DECISION DELEGATED TO HEAD OF PLANNING

Application No:	H20-0713-21	Applicant:	Mr & Mrs Githiri
Proposal:	Change of use of barn to residential dwelling using existing access		
Location:	Adj. Chestnut House Broadgate Sutton St James		
Terminal Date:	31st August 2021

PROPOSED
FLOOR PLANS & ELEVATIONS
SITE PLAN

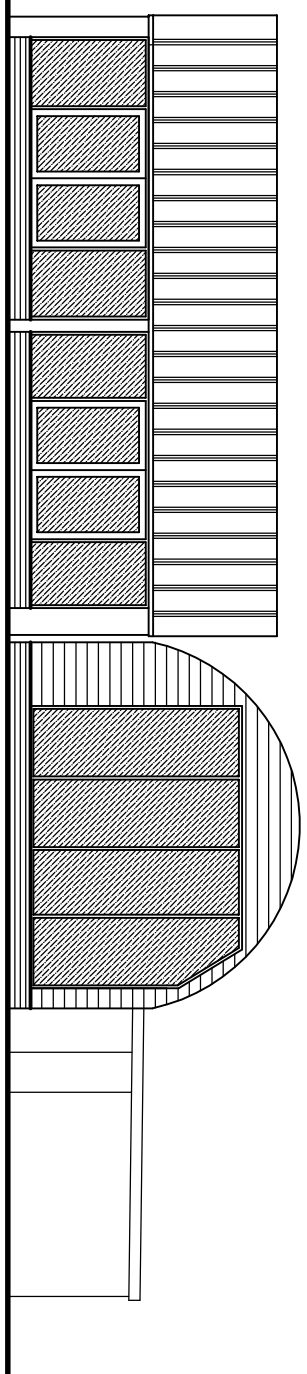
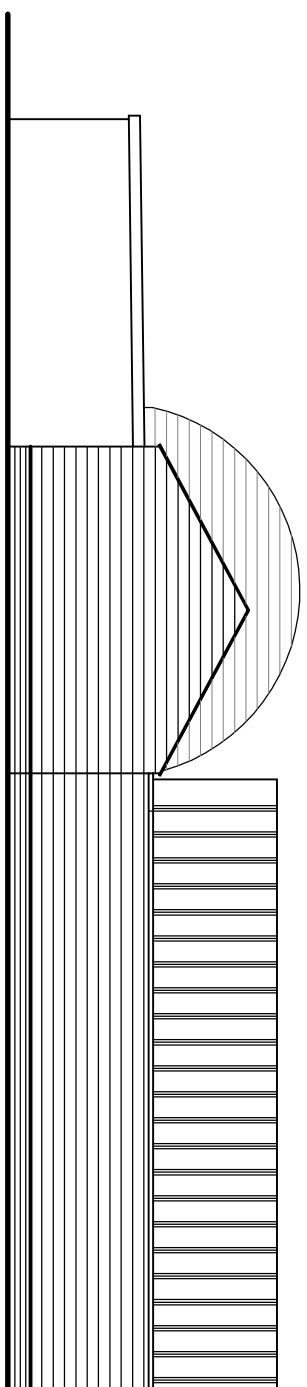
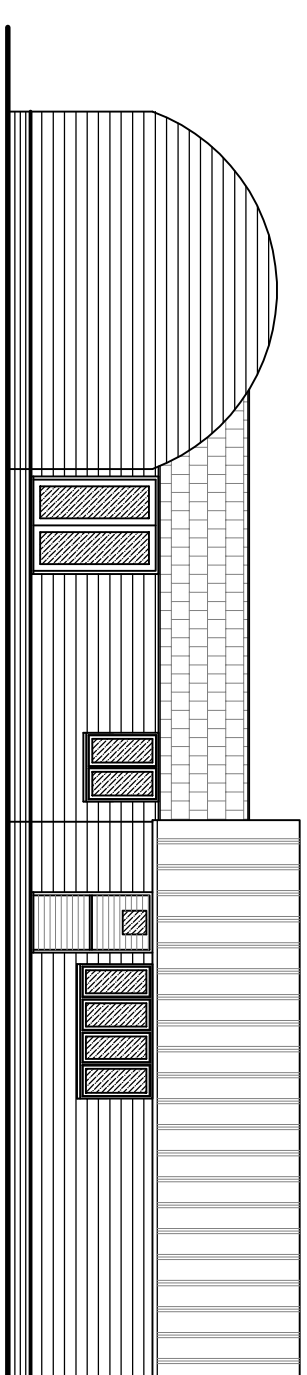
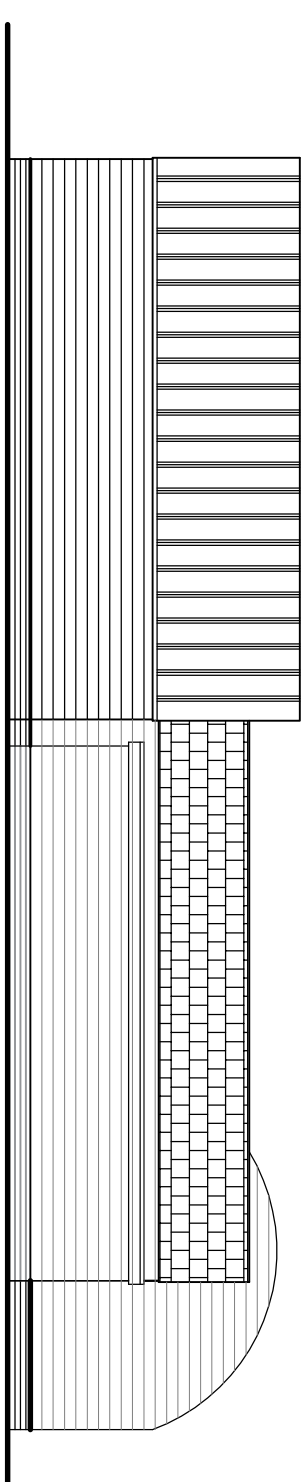
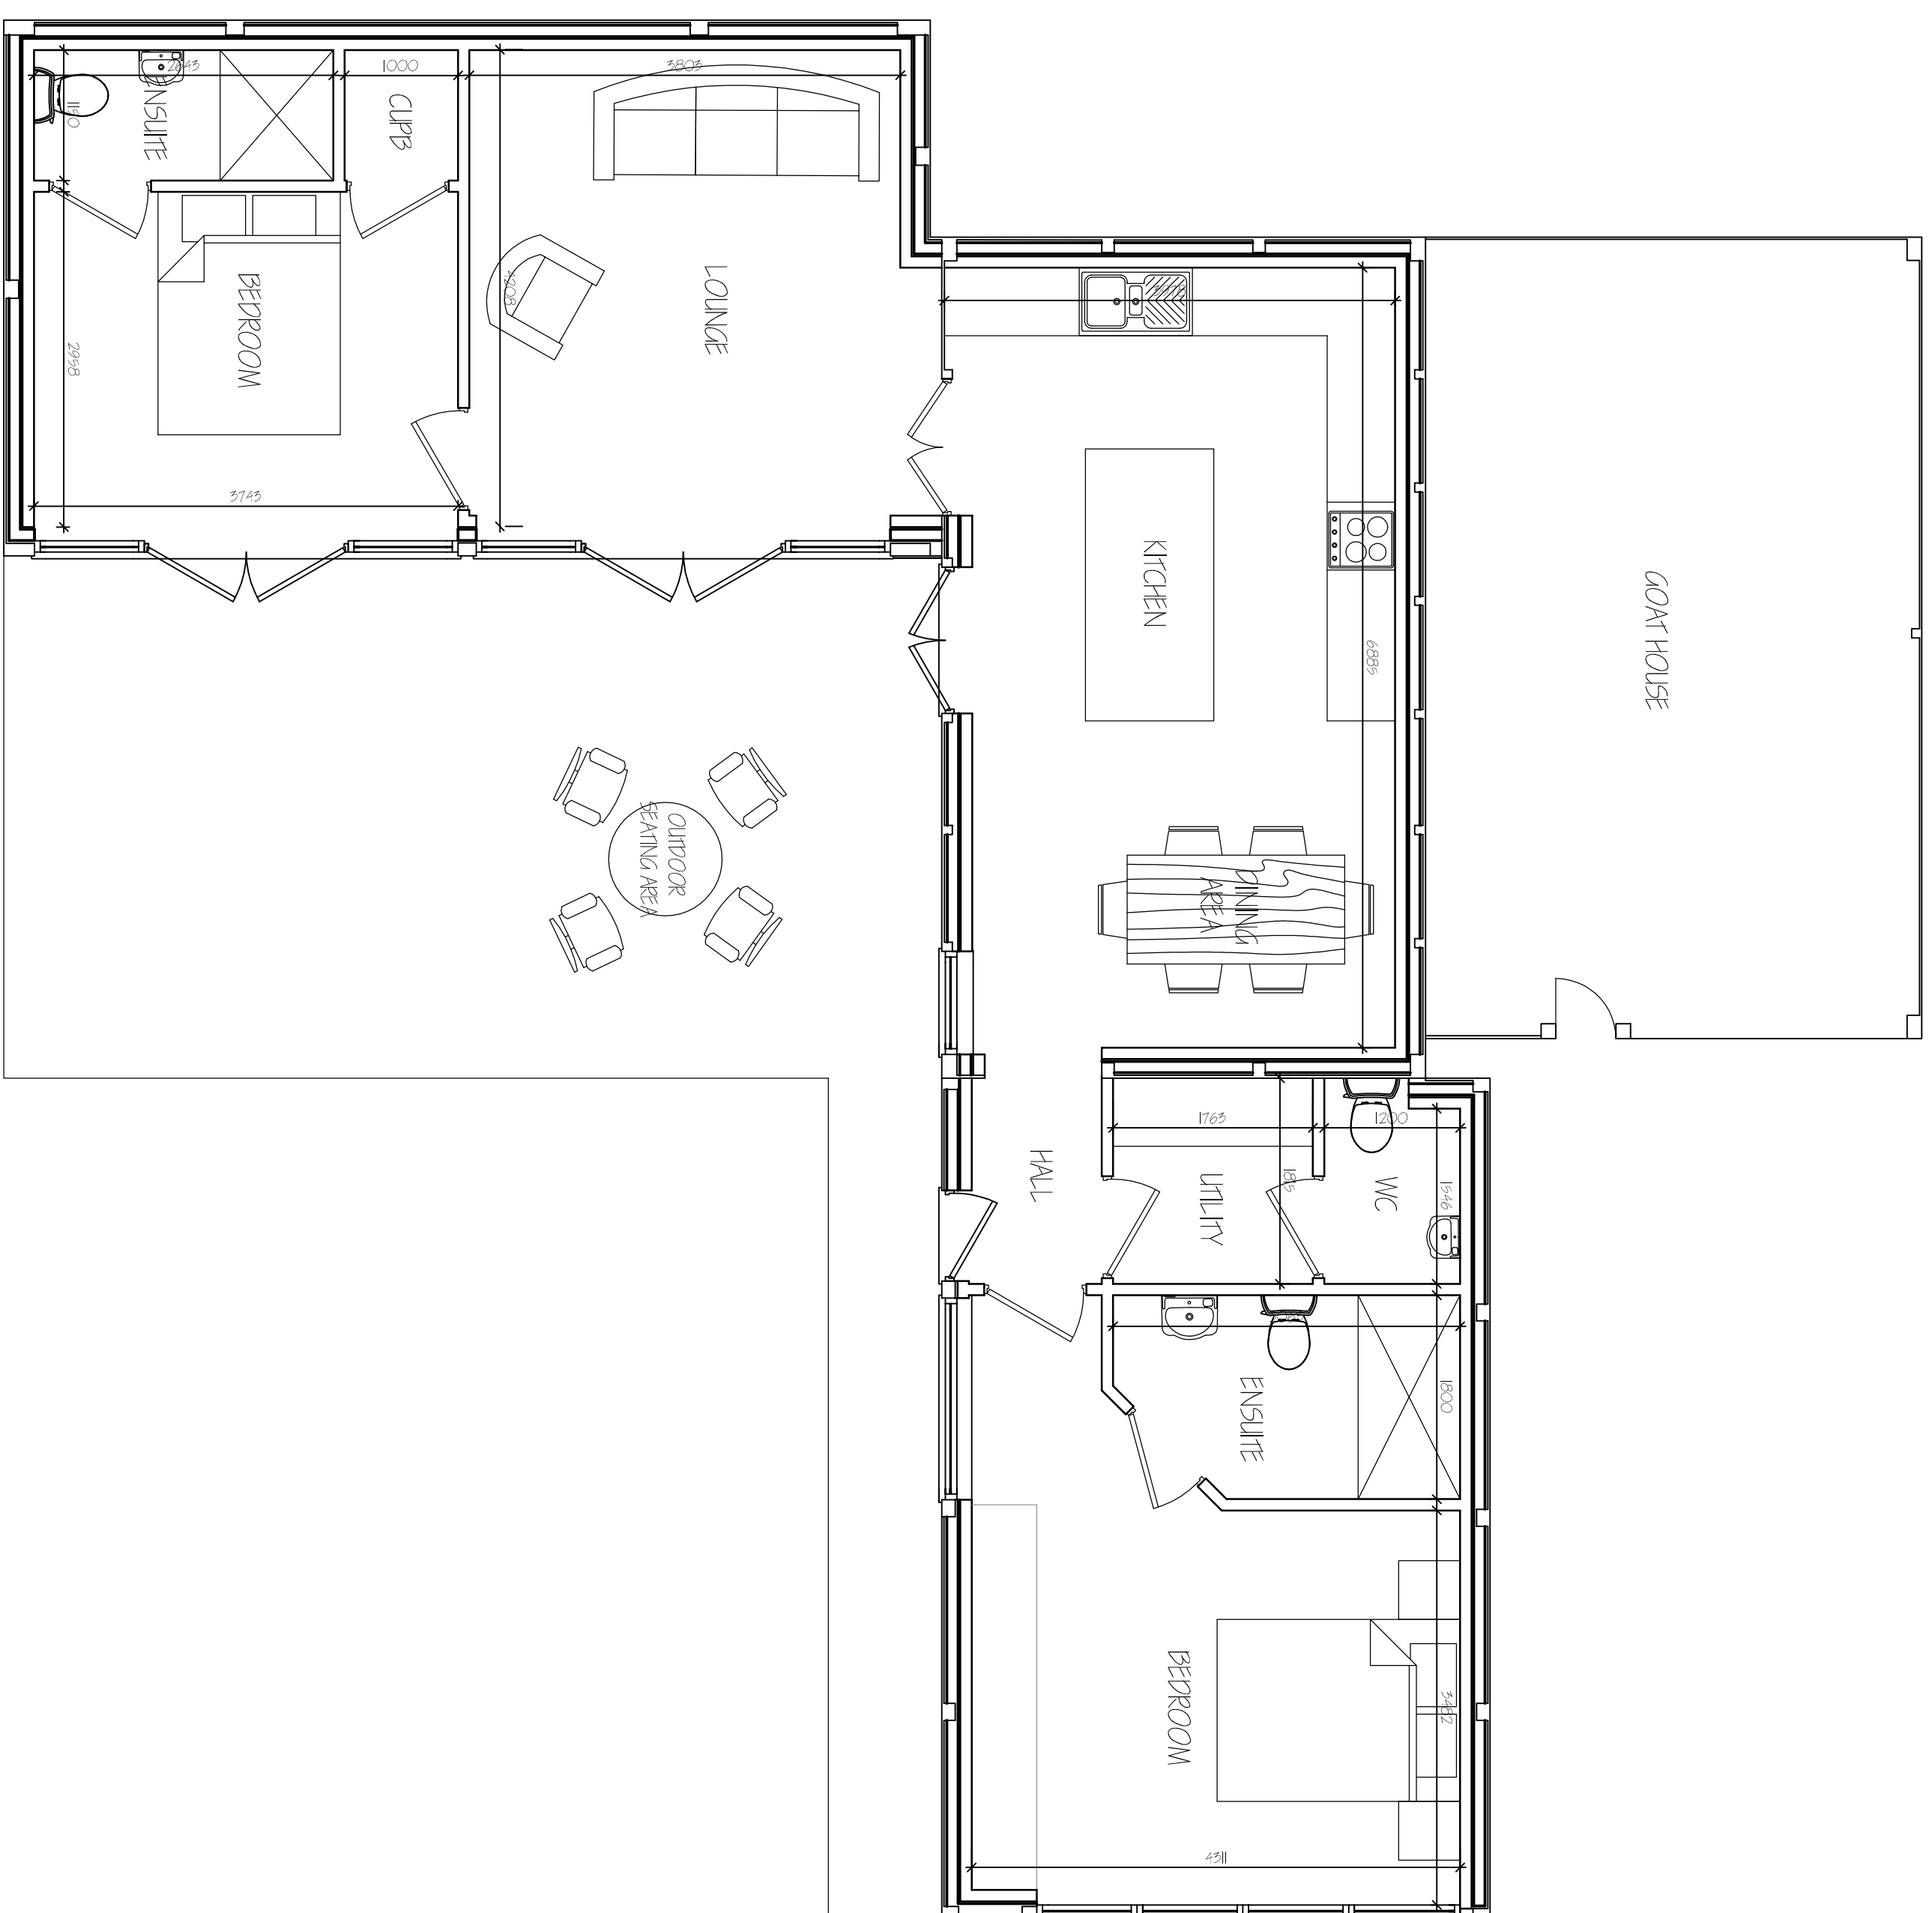
Zinc standing seam cladding would be used for the walls and roof. The application states that "this allows the existing tin to be replaced with barrel vaulted zinc roof sheets and will not affect the existing roof or wall structure. As to most conversions, a new floor and internal stud walling is required to comply with current Building Regulations, these do not affect or have any bearing on the existing structure therefore, by using standing seam zinc roofing sheets this will again have no bearing on the existing structure. This allows us to use the new floor and stud walls to construct a new timber stud roof internally to comply with the current Building Regulations."

The existing structure consists of a combination of timber and metal, some of which has deteriorated over the years and is no longer considered fit for purpose. It has not been satisfactorily demonstrated that the proposal would not involve new structural elements. No structural survey has been submitted. As such, it is considered that the proposed works fail to satisfy the requirements of paragraph Q.1(i) and the PPG. As a consequence, the proposal is not permitted development under Class Q(b) of the GPDO.

It has not been satisfactorily demonstrated that the proposal would not involve new structural elements. As such, it is considered that the proposed works fail to satisfy the requirements of paragraph Q.1(i). As a consequence, the proposal is not permitted development under Class Q(b) of Part 3 of Schedule 2 of The Town & Country Planning (General Permitted Development) Order, 2015.

SITE PLAN 1:200

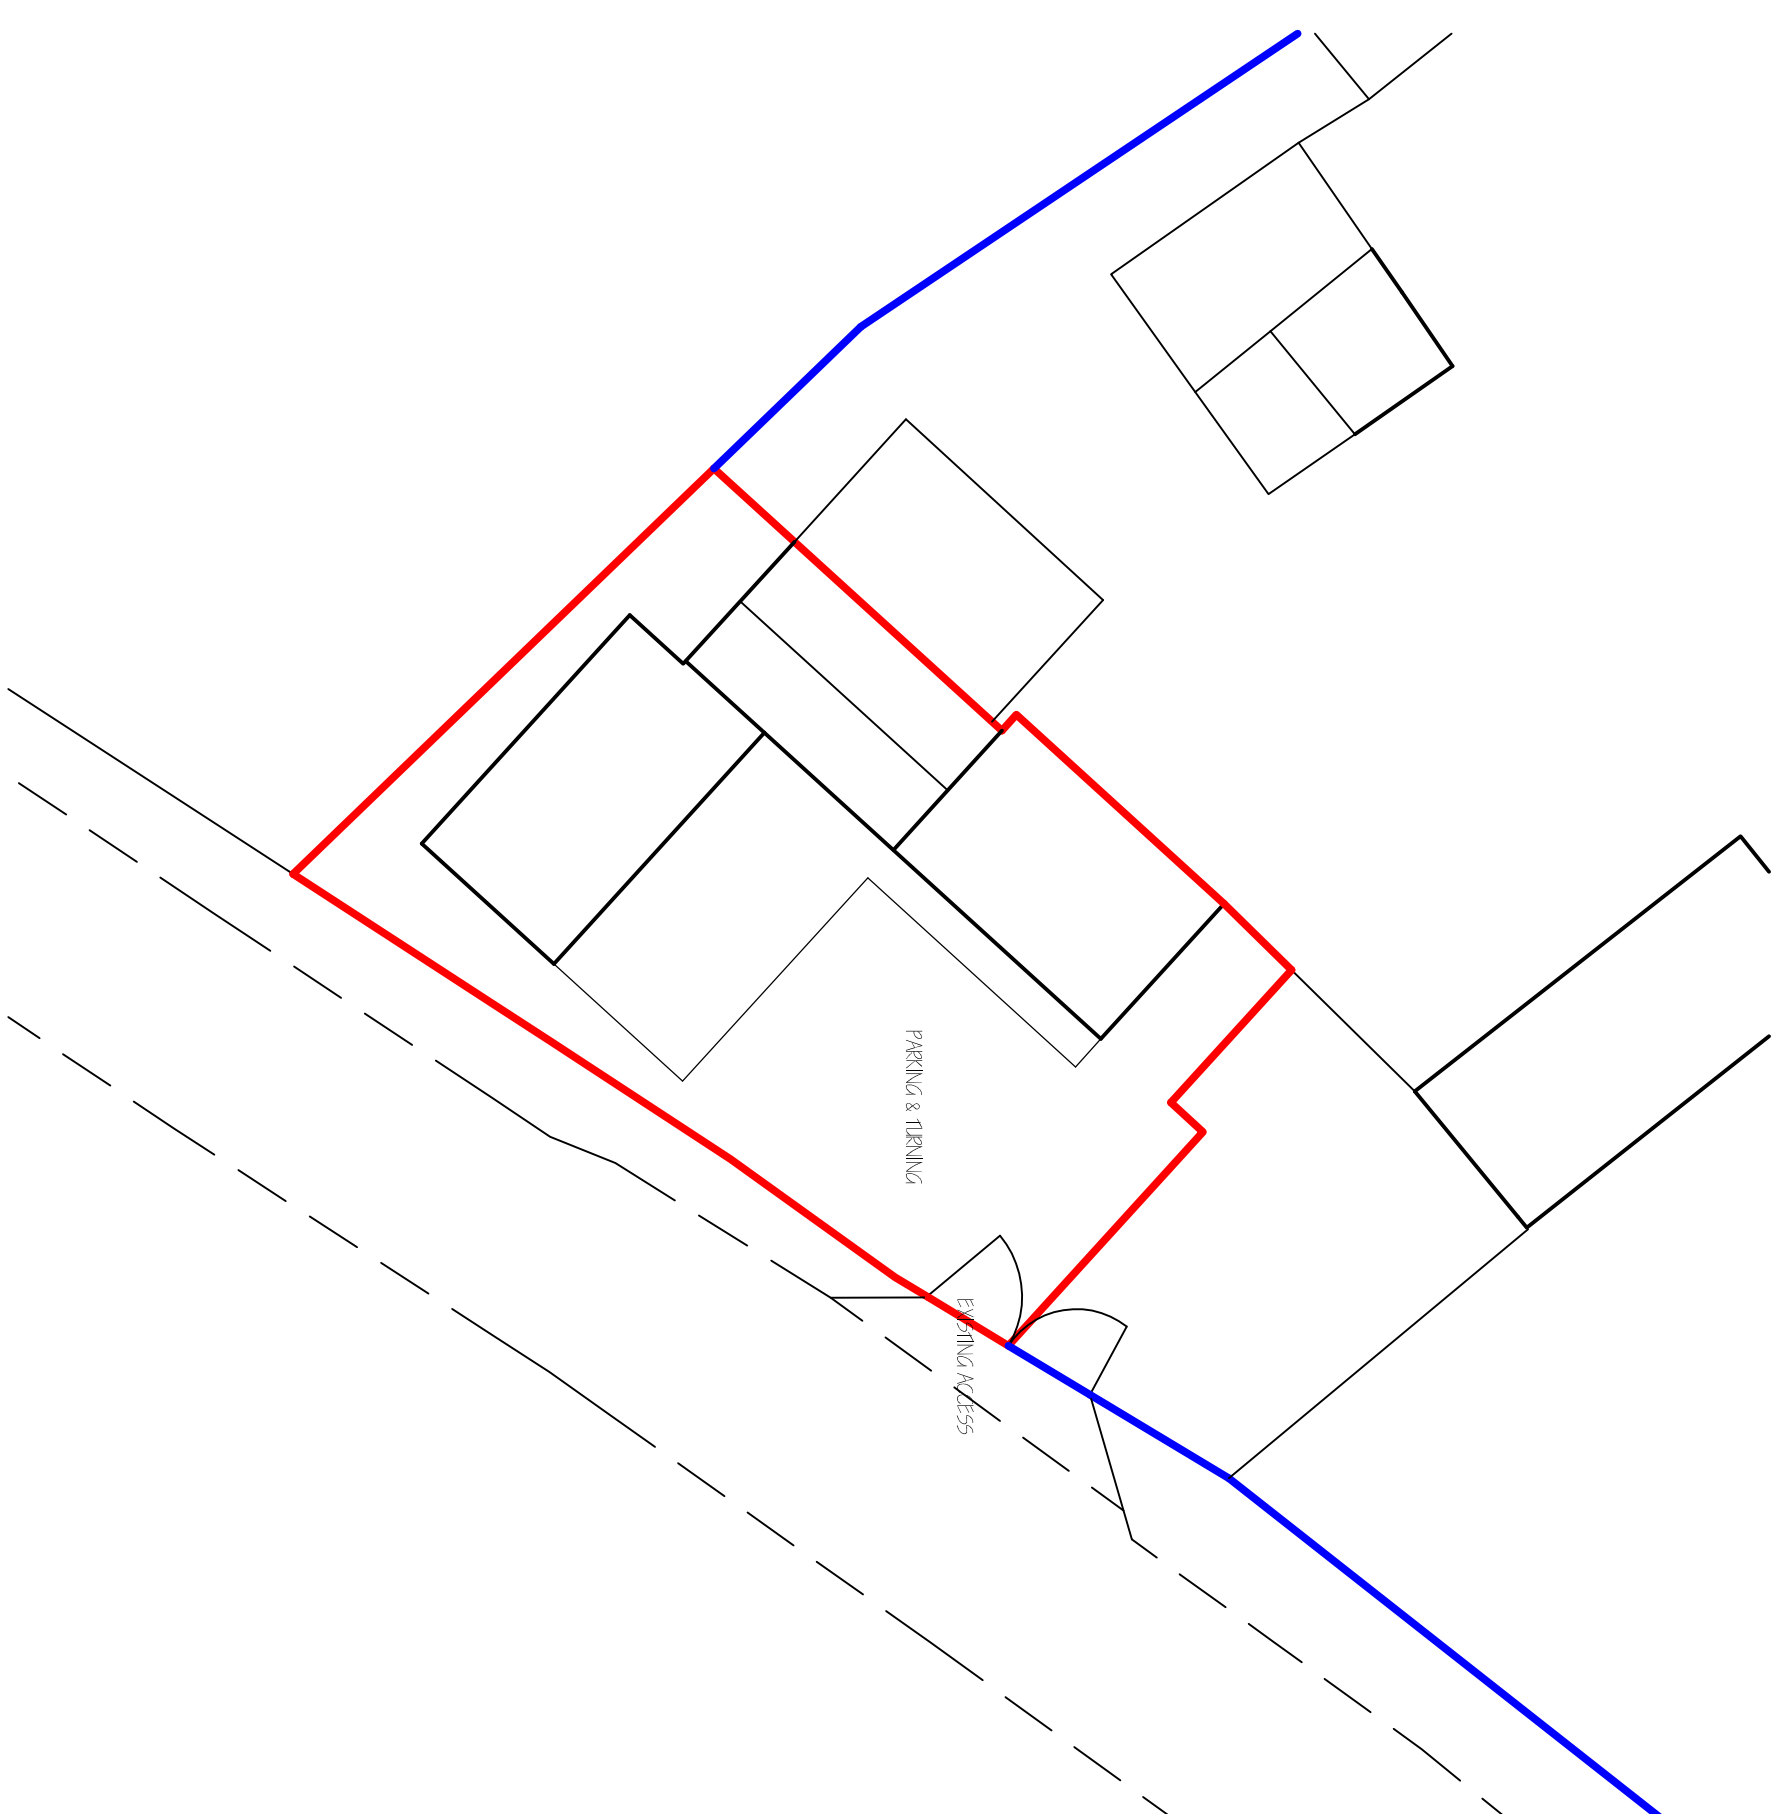
The proposed dwelling has been designed with no openings on its south-western or north-western elevations. Boundary screening could also be erected to alleviate any noise issues. It is considered that future occupiers would have an acceptable level of amenity and that the proposal would not unduly prejudice activity/operations on the neighbouring industrial premises.

In terms of siting, the buildings are in very close proximity to a preserved Ash tree. It is considered that their conversion to residential would lead to future requests to fell the tree and therefore prejudice its continued existence.

Moreover, an Ash (*Fraxinus excelsior*) tree, which is the subject of Sutton St James Tree Preservation Order No. 4, 1991, is situated immediately to the south-west of the buildings. The development would, if permitted, compromise the tree and result in pressure to remove it, thereby prejudicing its continued existence, to the detriment of the visual amenities of the rural locality.
